**Consultation Response from KC,
Lead Local Flood Authority**
2025/93394 Rowley Mills, Penistone Road, Fenay Bridge, Huddersfield, HD8 0LE
Erection of 3 storey front extension and 2 storey rear extension of Rowley Mills with associated car park amendments, ancillary structures and landscaping; first floor roof extensions, car park amendments and landscaping at International House with new access infrastructure and pedestrian crossing facility
Date Responded: 14/01/2026.
Responding Officer: Martin Stephenson
Responding Ref: 1
Documents reviewed by the LLFA:

SCALE	PAPER	STATUS
1:250	A1	PRELIMINARY
DRAWING NO.	REV.	
23308-DCE-XX-XX-D-C-102	P01

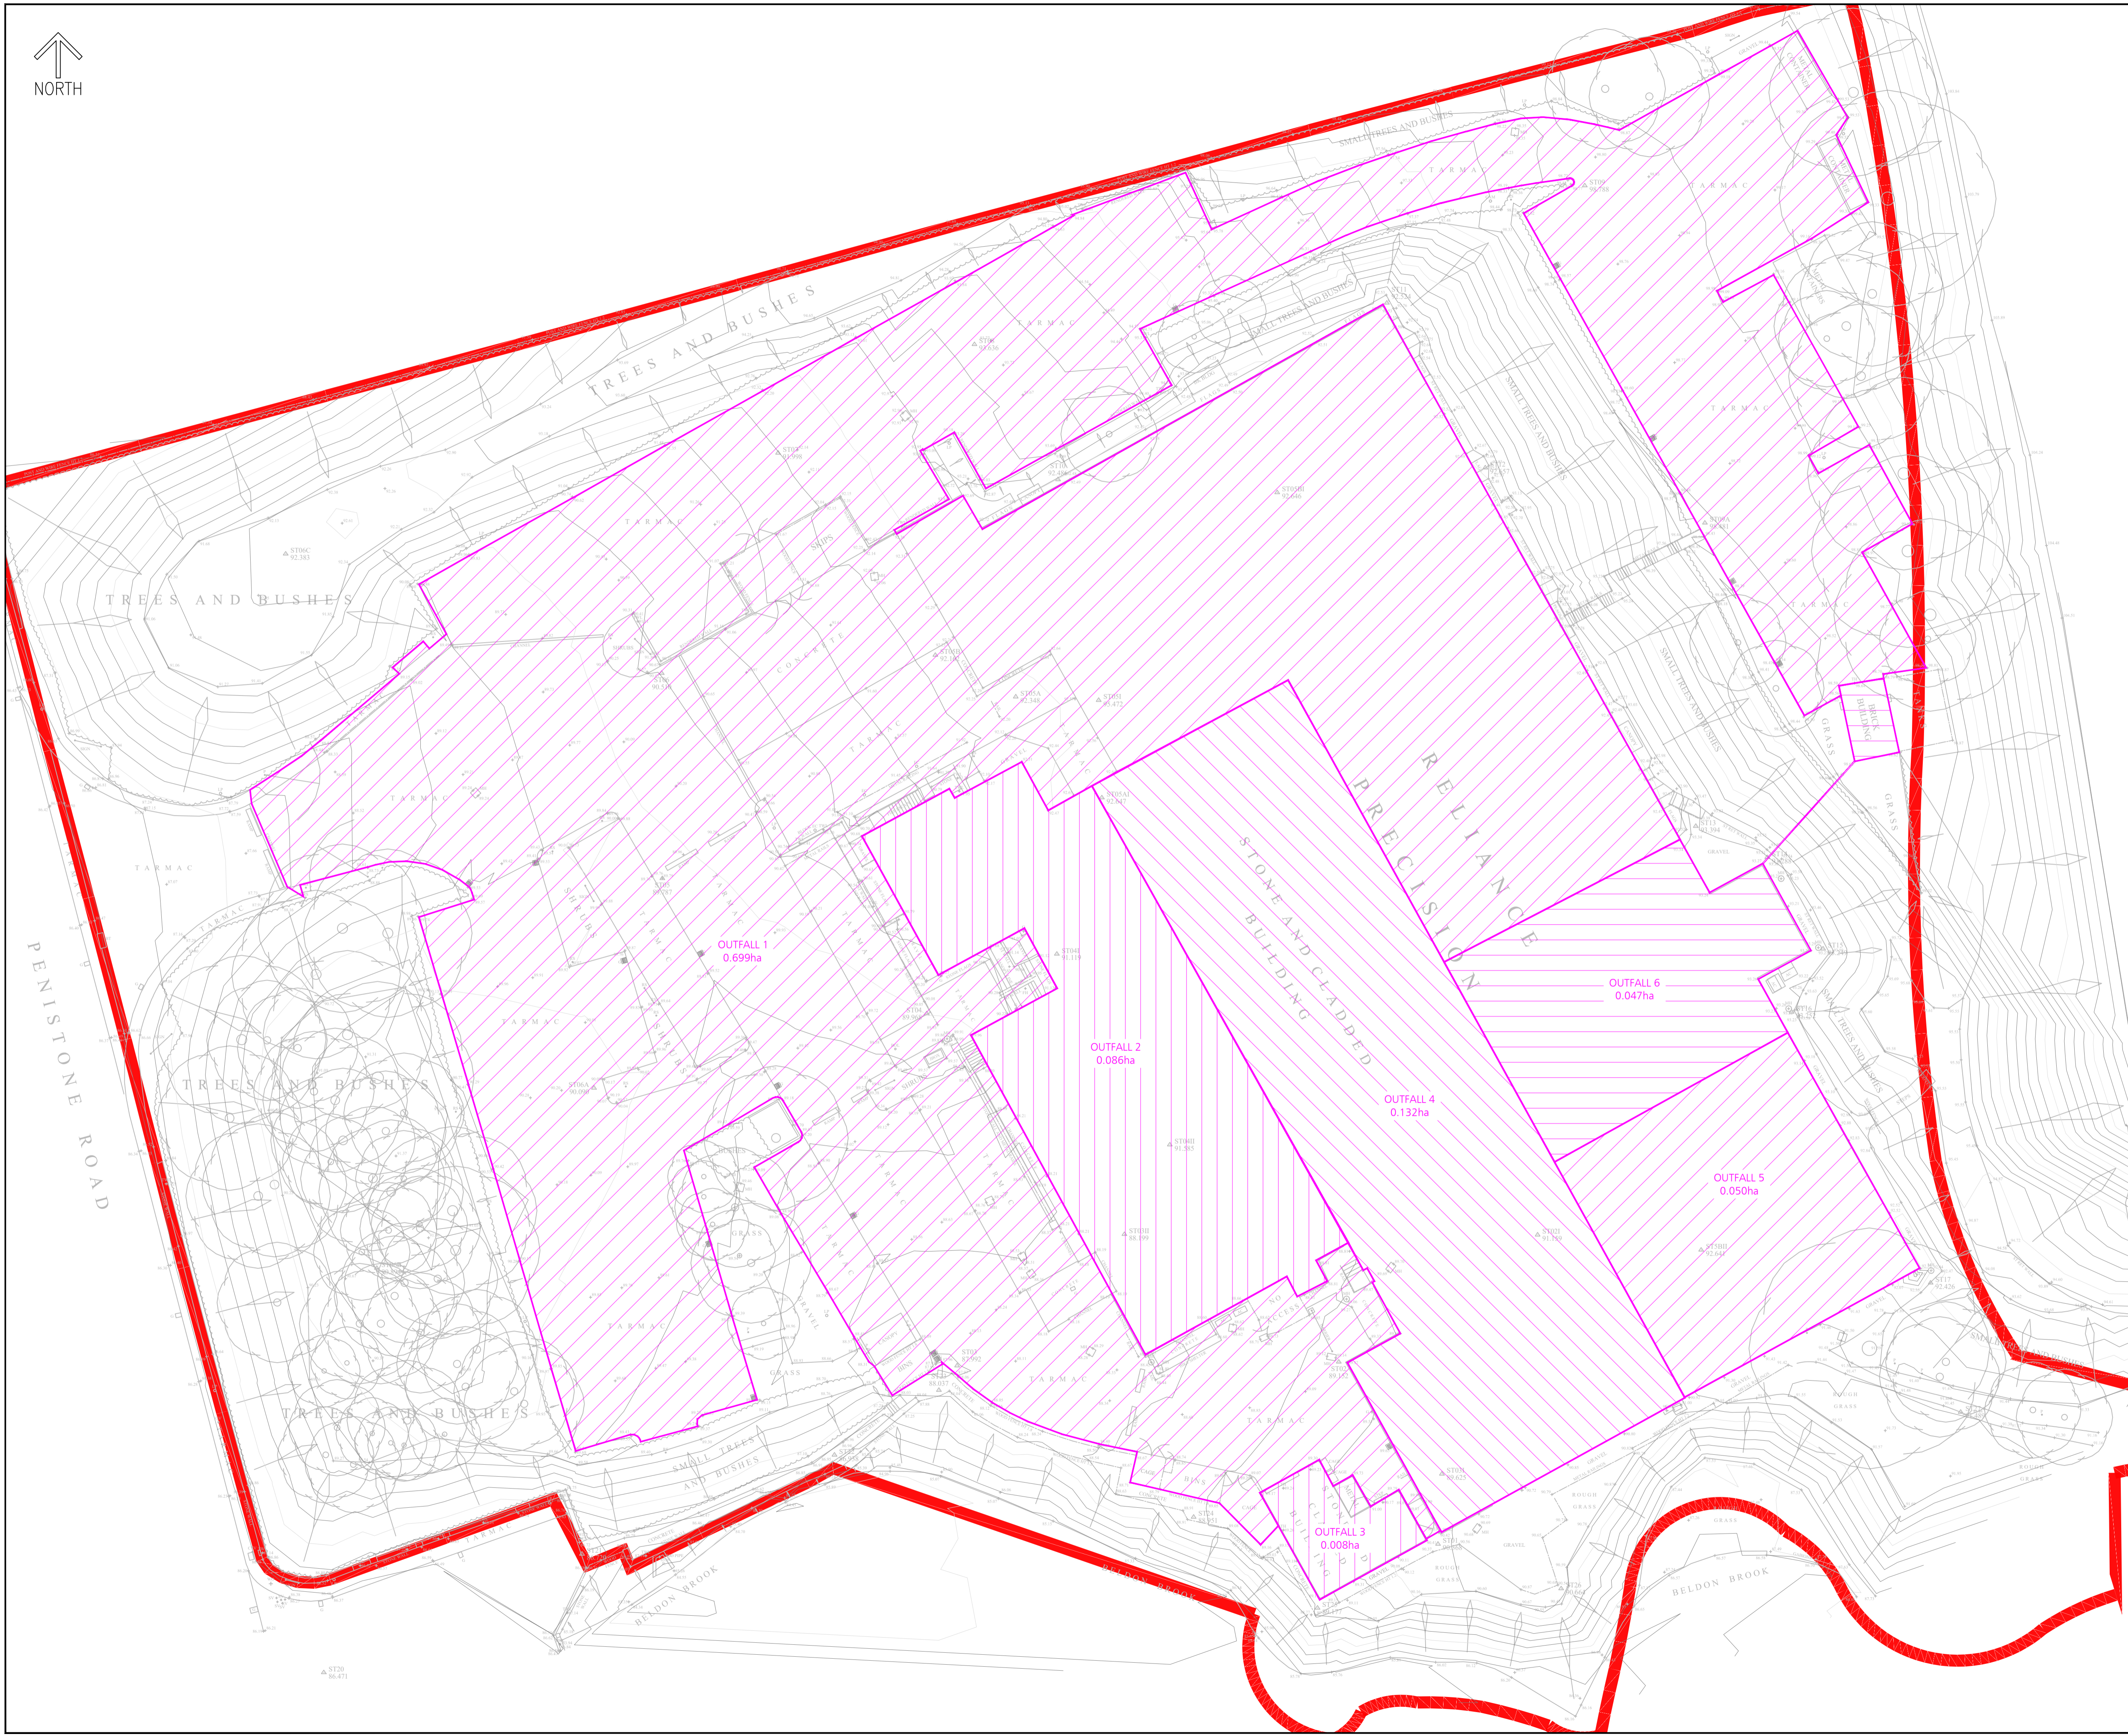
NOTE: the MH connected to the Attenuation Tank should be of the silt trap type to reduce the risk of siltation within the tank and access points should be provided into the tank for easier inspection and maintenance.
